DRAWN BY: D.E. WATTS DATE: 12-10-20 DWG. NO.: 20-5564-01 SURVEYED BY: DEW, ESV, 12-10-20	APPROVED BY: PROJ. NO.: DWG.:	REVISIONS:	OLIVER E. WATTS CONSULTING ENGINEER COLORADO SPRINGS	PROJECT: 16810 SOUTH PEYTON HIGHWAY PART NE S8, T.17S., R.63W., 6TH P.M. EL PASO COUNTY, COLORADO	SHIT. NAME: SITE PLAN	SHIT. NO.: 1 OF 1
---	-------------------------------------	------------	--	--	---------------------------------	----------------------------

Site Development Plan_V1.pdf Markup Summary

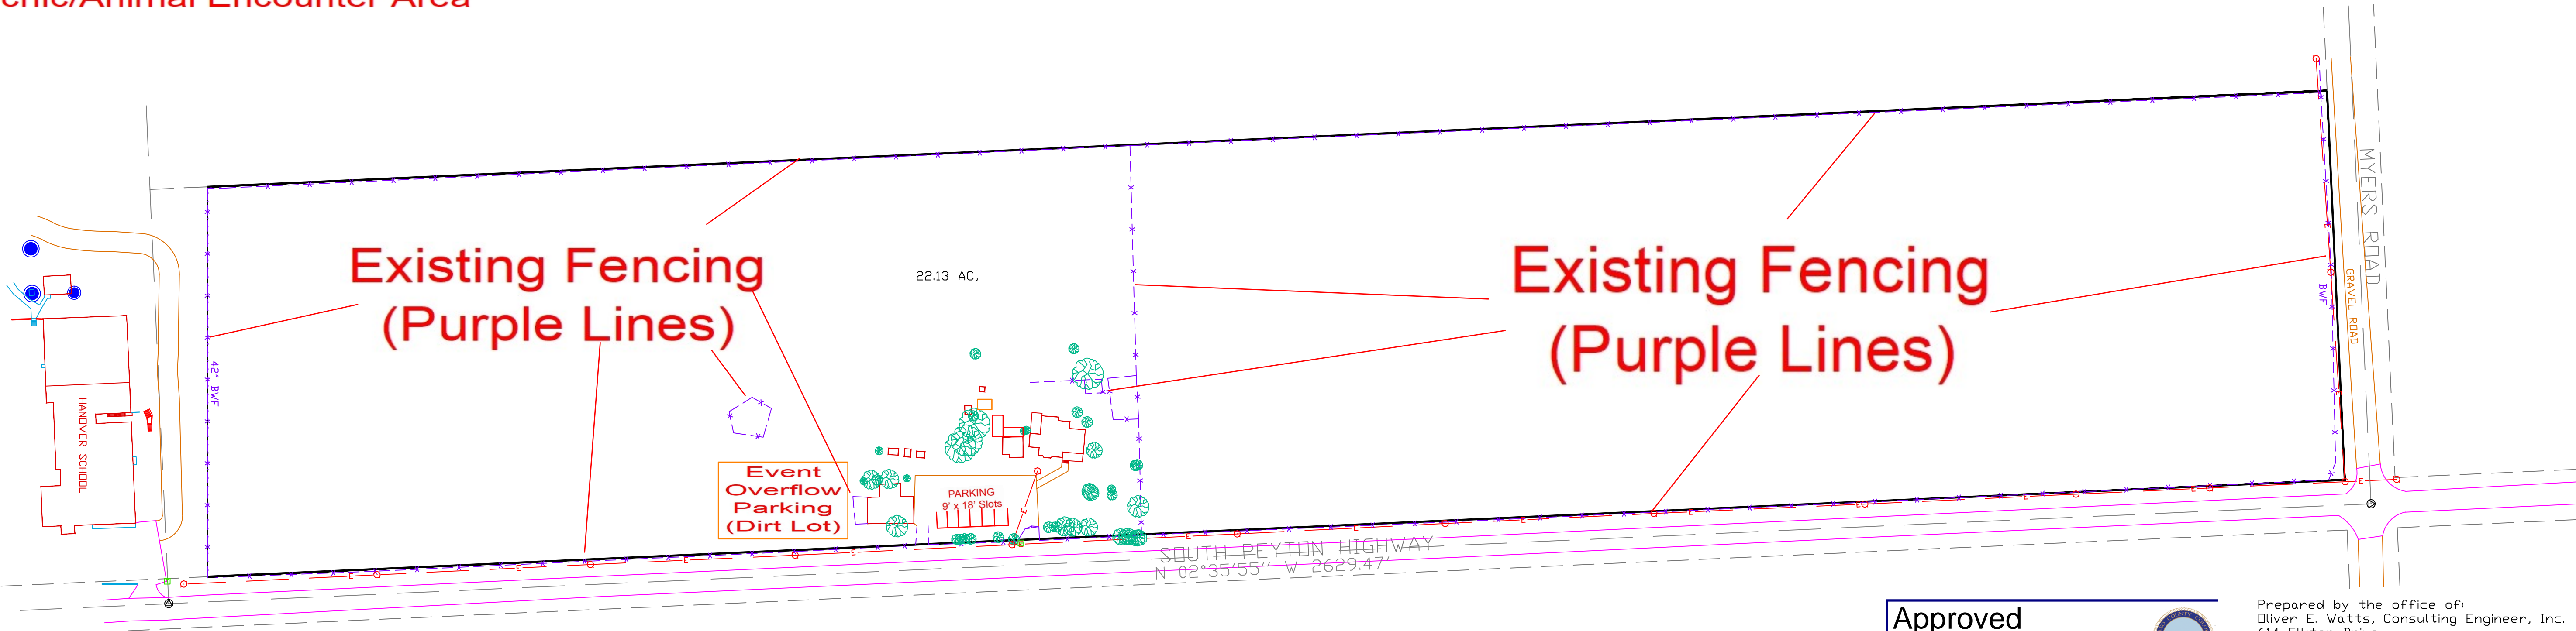
1. Please show the proposed petting zoo enclosure location, as well as indicate the area(s) where the animals are/will be kept at various times (during events vs. day/night times). Also show the proposed teaching / picnic area with benches as noted on the special use site plan (refer to comment 2 below for additional). Please show measurements for all of these areas (letter of intent describes measurements of these areas but the plan doesn't show them).

2. The associated AL1928 site plan differs considerably from this one in terms of level of detail. The associated special use approval identifies that the approved letter of intent and site plan for that project must be consistent with this letter of intent and site plan. Please refer to the site plan and letter of intent for AL1928 and ensure that this plan shows all information and use components shown/described in the plan and letter of intent. All use components will need to be shown.

3. Please add note that identifies all structures as existing

4. Please show existing and proposed fences on plan as well as on the legend.

5. Show measurements for parking spaces (measurements described in letter of intent but plan doesn't show).

6. If pumpkin patch shown on landscape plan is to be included in the agritainment use, then please include it in the letter of intent and site plan.

7. Show adjacent property lines, zoning, and land uses.

8. Identify entry drive and drive aisle(s) and their width. Also show existing gate near parking.

No access permit for the primary access is on file. Please apply for a primary and a second driveway access permit through EDARP under initiate minor application.

Please provide a driveway detail for the two driveways.

Update to show drive to overflow parking. Additional access to overflow parking from public ROW will not be possible if a second access point to the 6 parking slots is approved. Also, indicate size of the overflow parking as well as the type of cover that will be used for it (asphalt, concrete, dirt, gravel).

Add the following text: "PCD File No. PPR-21-015".
